The following represents a rejoinder to the Applicant Response to Stop Greenhill Solar Written Transport Response (**EX6/GH8.2.20, March 2026**). Plus: **Addendum** on proposed A43 major road works.

Addendum: Proposed road development works on A43 in 2028

Title:
Figure 13.3 (Rev A): HGV Routes to Scheme
(North Area)

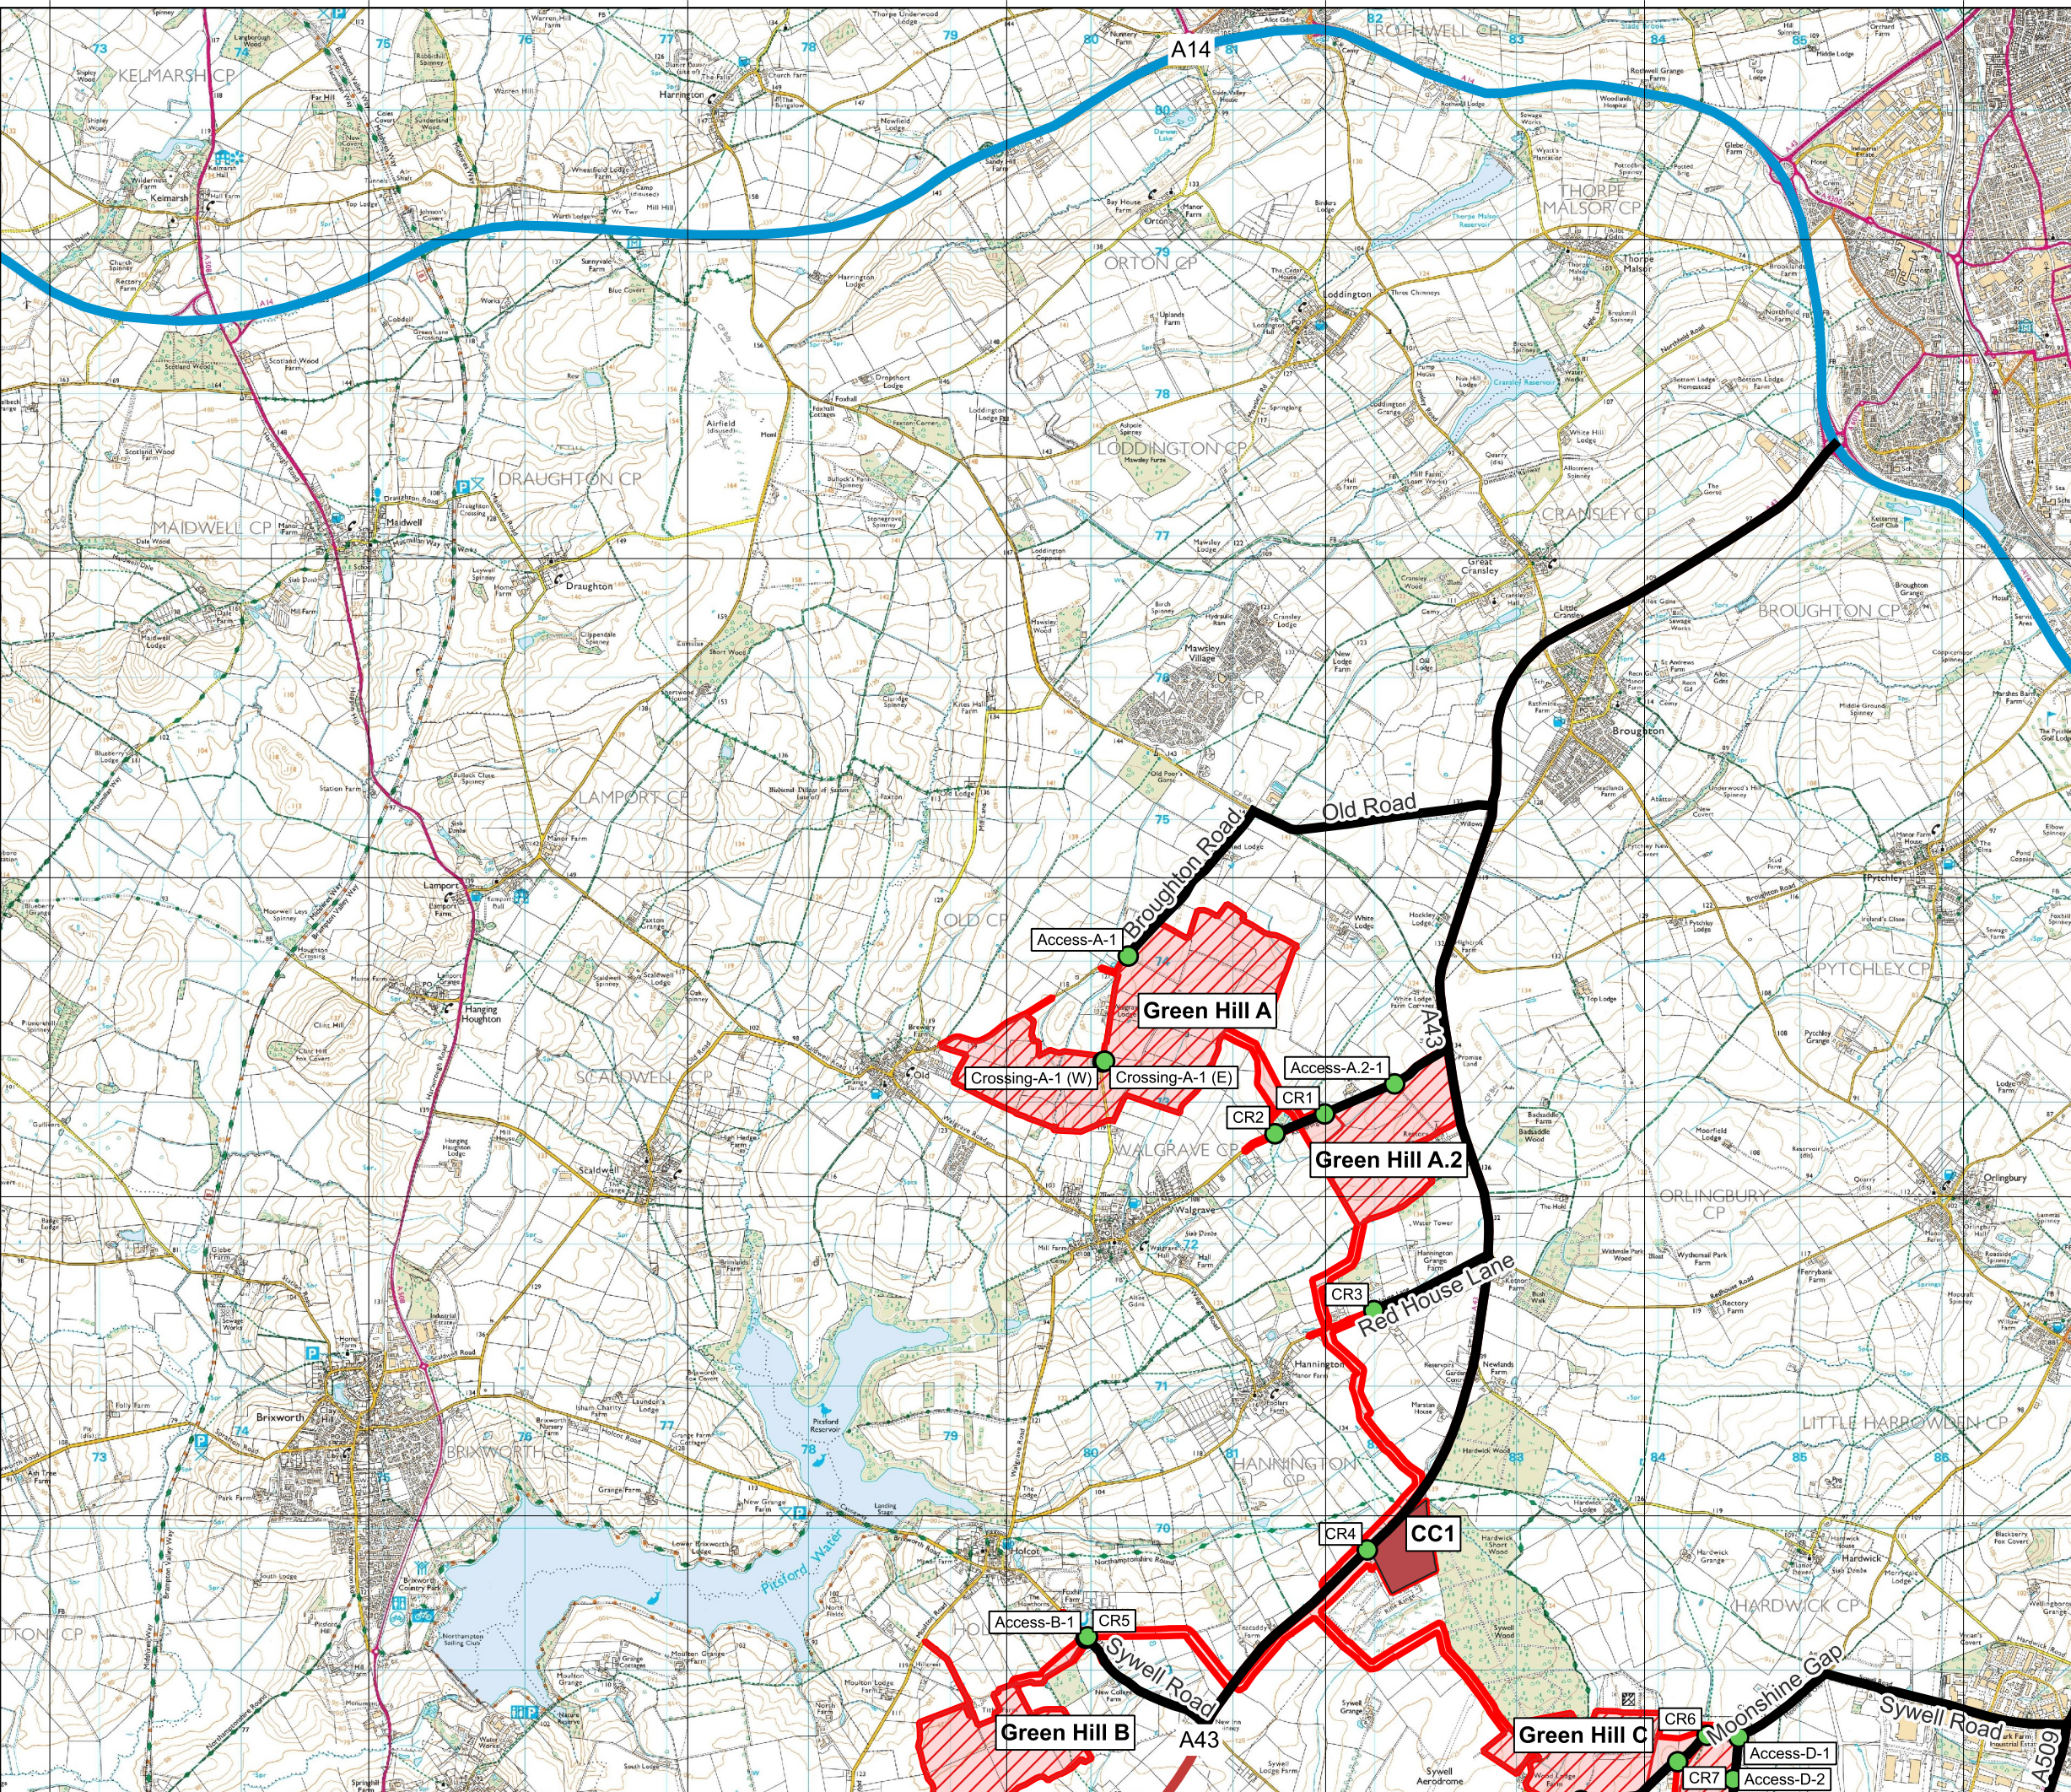
Construction Compound 1 is positioned on the southbound carriageway of A43, north of the Sywell roundabout. As discussed in ISH 5, the road is too busy most of the time for construction traffic heading to sites A and A2, to turn right across the traffic flows. The vehicles would need to turn left southwards down to the Sywell roundabout, do a 360-degree turn and head back northwards. All traffic to and from Site B would also be using this roundabout. The GHS representative present at the meeting, in his response at the time, confirmed that the construction vehicles would be instructed to only turn left out of CC1 and then turn round at the roundabout.

However, information from West Northants Council indicates that it is likely that **significant roadworks** will commence in 2028 and finish in 2029 to dual the A43 up to this roundabout, which will likely cause considerable disruption to the busy A43, exactly at the same time as the extra Green Hill Solar construction vehicle traffic would be added.
